ENG-SF19014-R4-MDDP-Redlines.pdf Markup Summary

ENG-SF19014-R4-CD-Redlines.pdf Markup Summary

ENG-SF19014-R4-GEC-Redlines.pdf Markup Summary

Project No: CLH000014.20
Drawn By: JDP
Checked By: RGD
Date: 4/17/2020
BENT GRASS MEADOWS
DRIVE STORM PLAN &
PROFILE

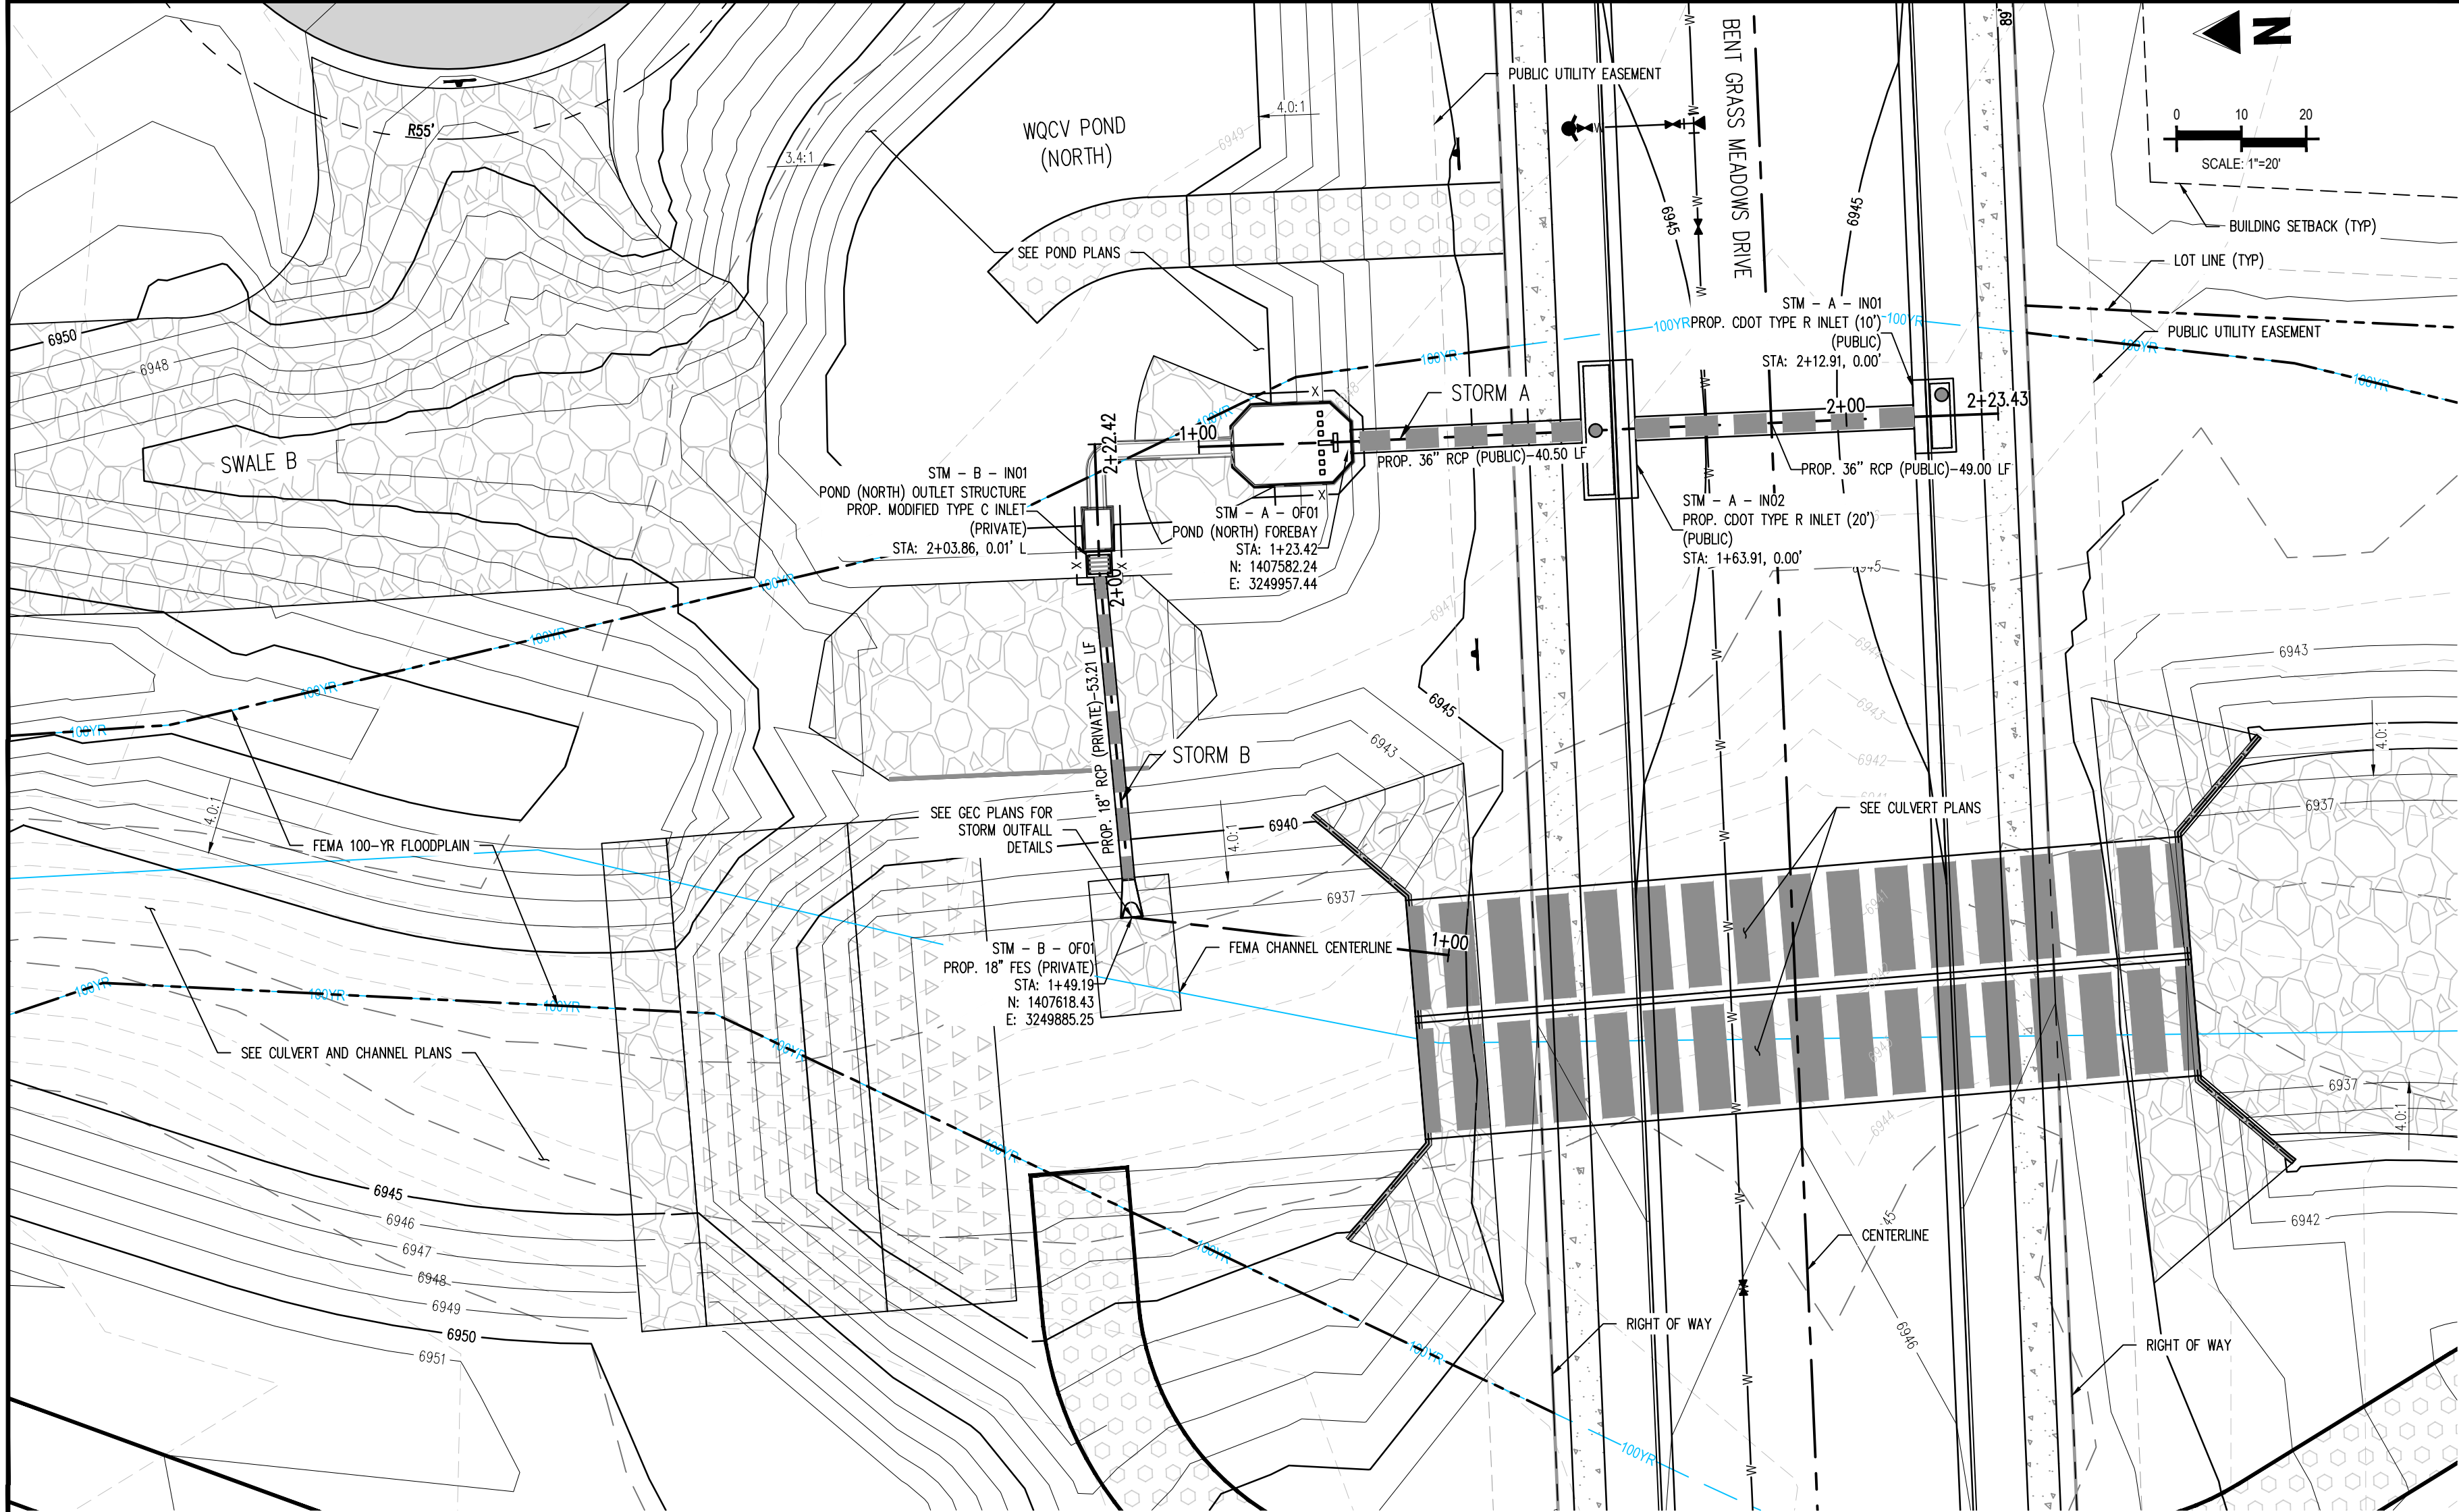
TYPE C INLET
(PUBLIC)
-03.86, 0.01' L

BERWYN LOOP STORM
PLAN & PROFILE

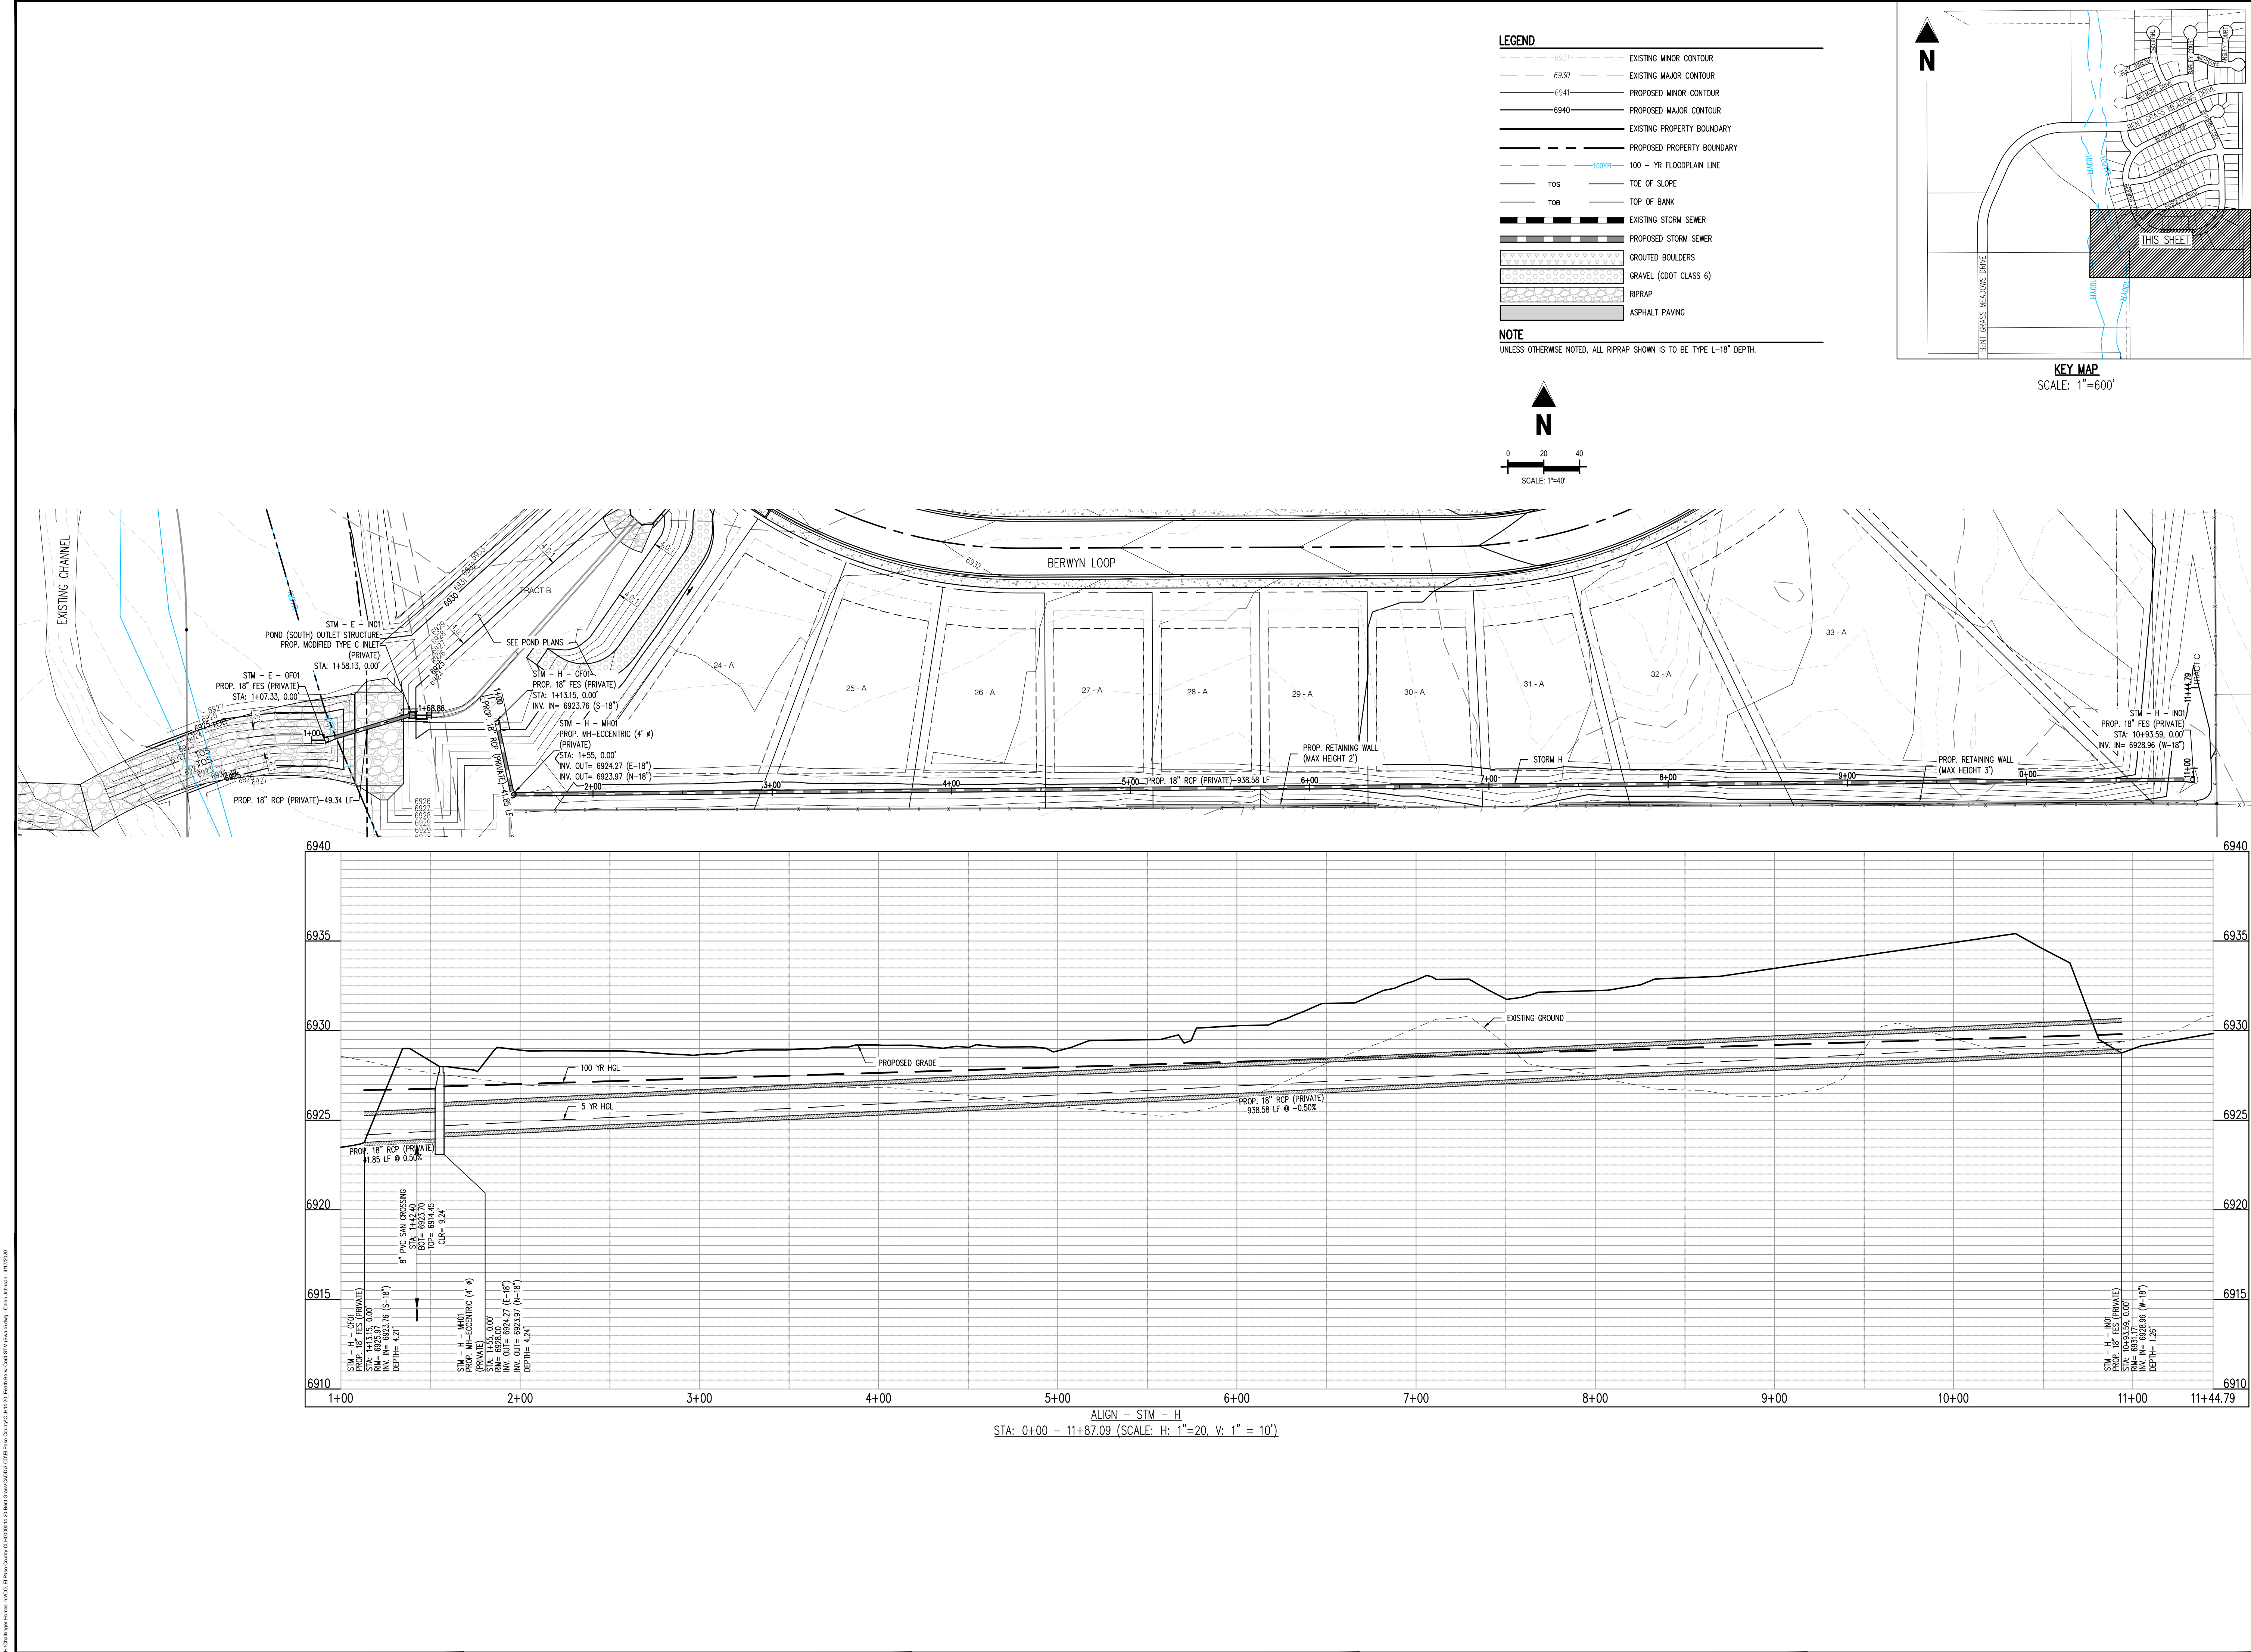
Subject: Text Box
Page Index: 28
Date: 4/8/2020 9:13:13 AM
Author: dsdrice
Color: ■
Layer:
Space:
Page Label: [28] 28 BERWYN LOOP STORM PLAN & PROFILE
(District)(?)

STORM H - PLAN & PROFILE

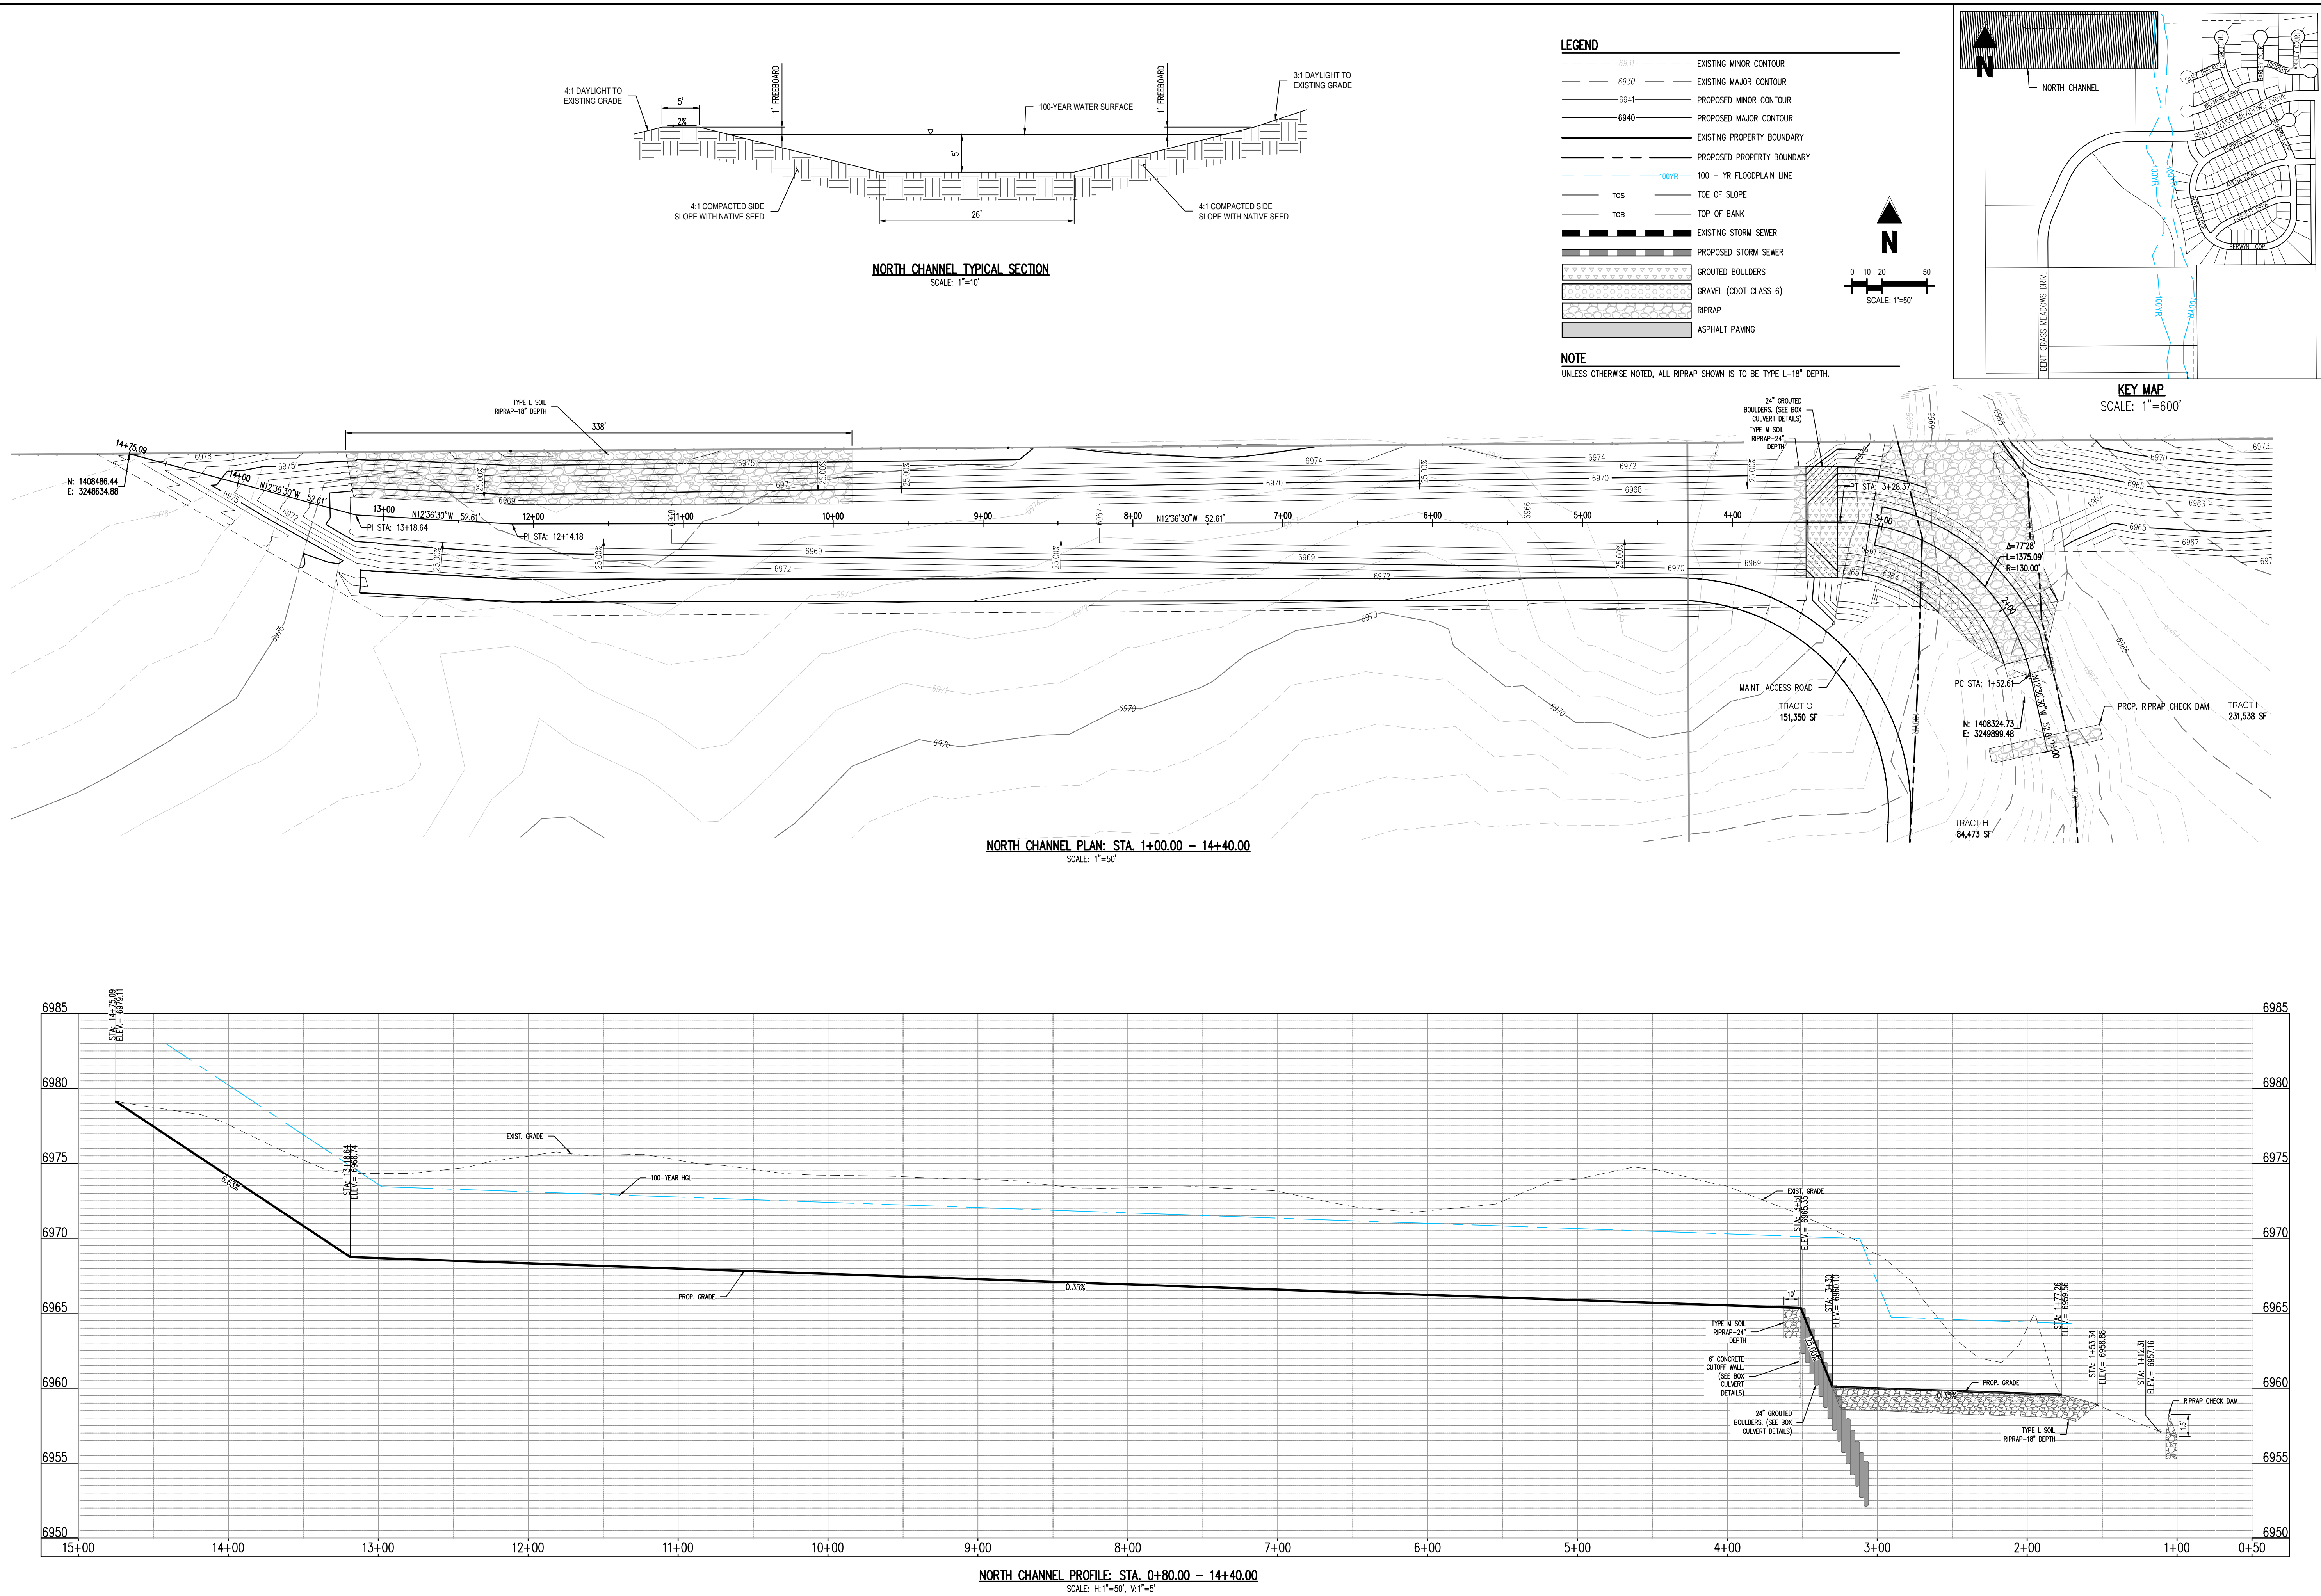
It appears that a berm is needed. Verify culvert headwater depth calculation.
